Historic England

26 January 2020

**LAND ADJ TO PROMISED LAND FARM, WENDLEBURY ROAD, CHESTERTON,
OXFORDSHIRE
Application No. 19/01746/OUT and 19/01740/HYBRID**

Figure 1.3 – Site B

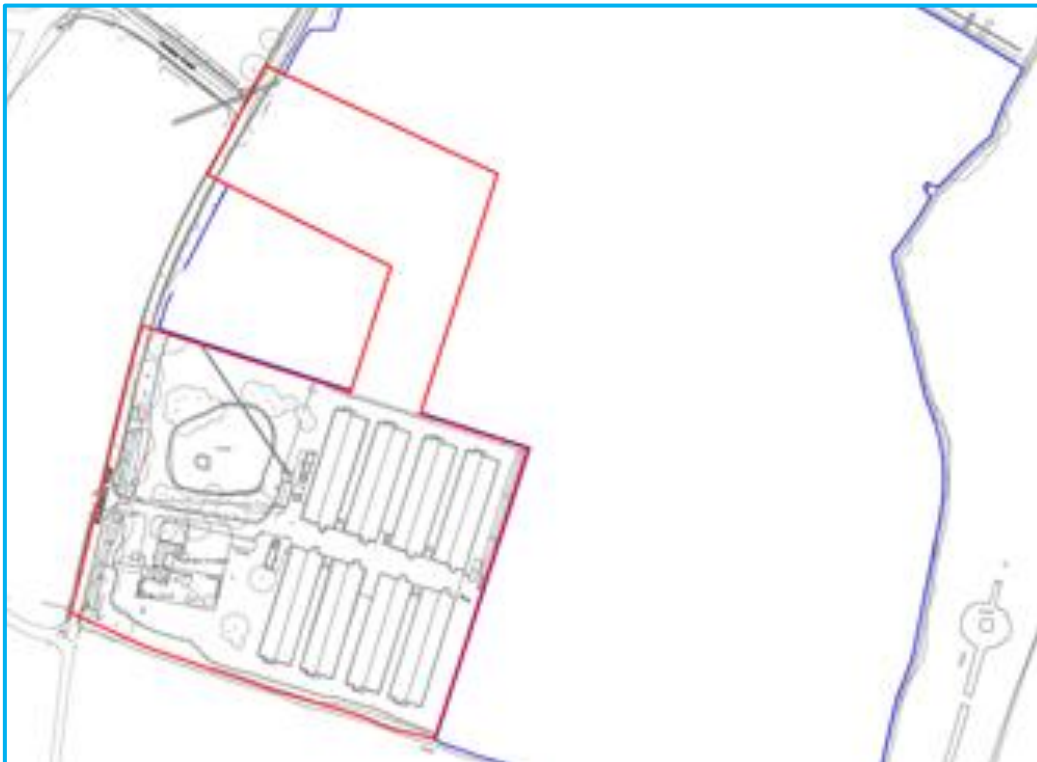
Proposals for Site B currently show a narrow no-build zone between the proposed buildings and the edge of the site bordering the scheduled monument. The revised DBA should clarify what role this is intended to play in relation to the monument, if any. Is this intended to reduce the impact on significance as contributed to by the setting?
